## Honeycutt Hills Community

Lot 46 – Millhaven Model

**WALL SHEATHING**

M+K Project #: 126-23047 (40/01)

sheet:
S4.0

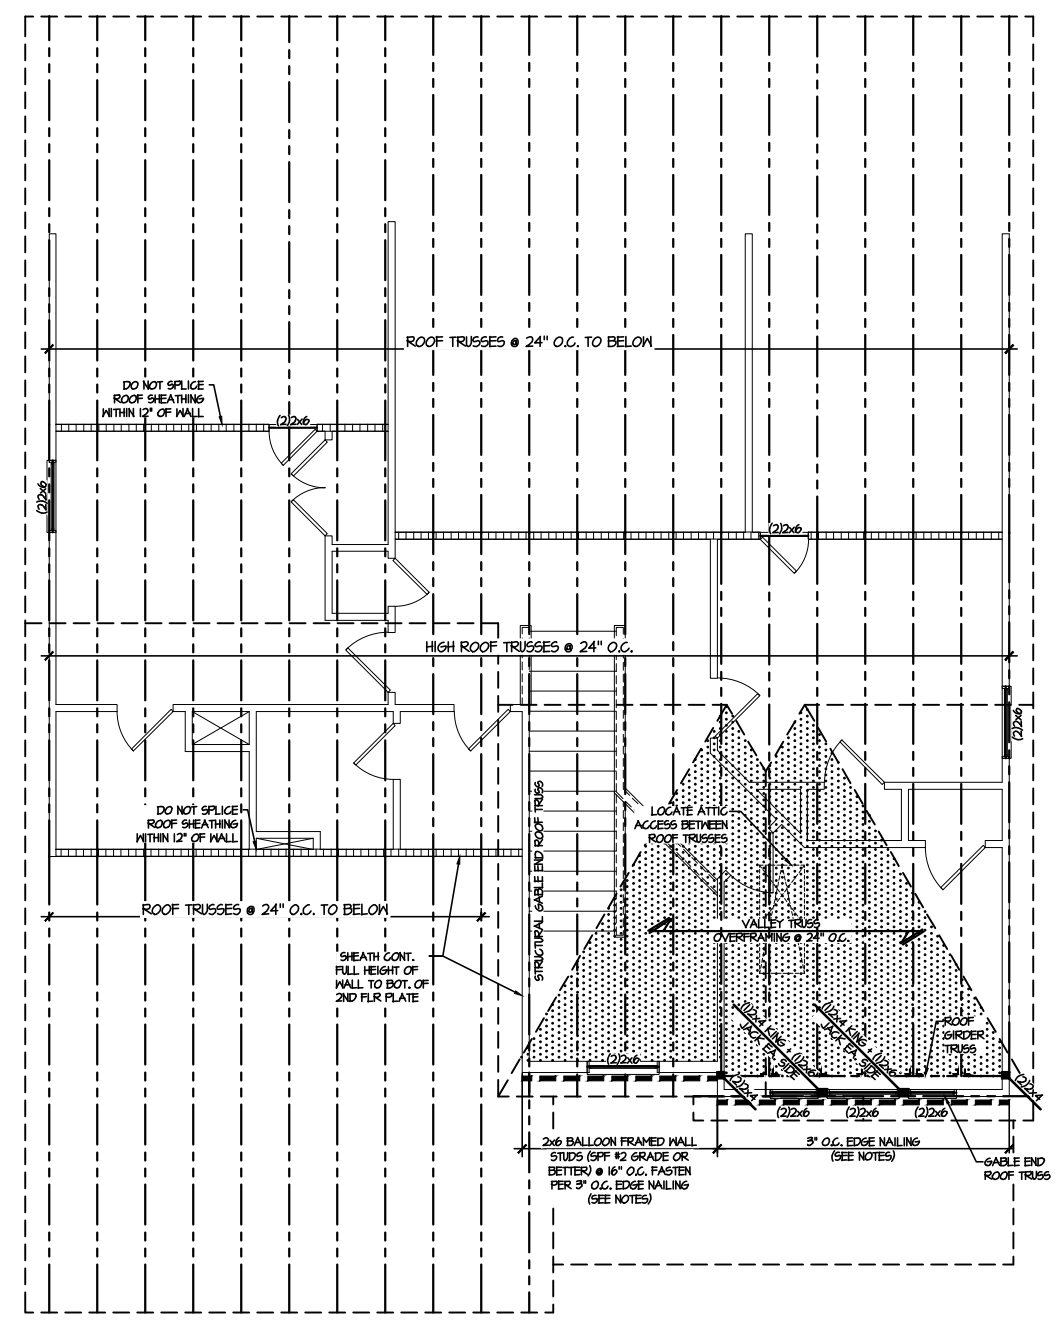
Pursuant to your request, we have prepared this letter to address the roof sheathing splice above the bearing wall of the upper level bedroom on sheet S4.0. It was reported to you that our note on sheet S4.0 that reads “do not splice roof sheathing within 12” of bearing wall” was not followed. It was also reported to us, by you, that flat blocking was added at the roof sheathing splice, and fastened per our typical roof sheathing fastening specification.

**We have analyzed this condition, and it is our professional opinion that this is structurally adequate and no repair details are required.**
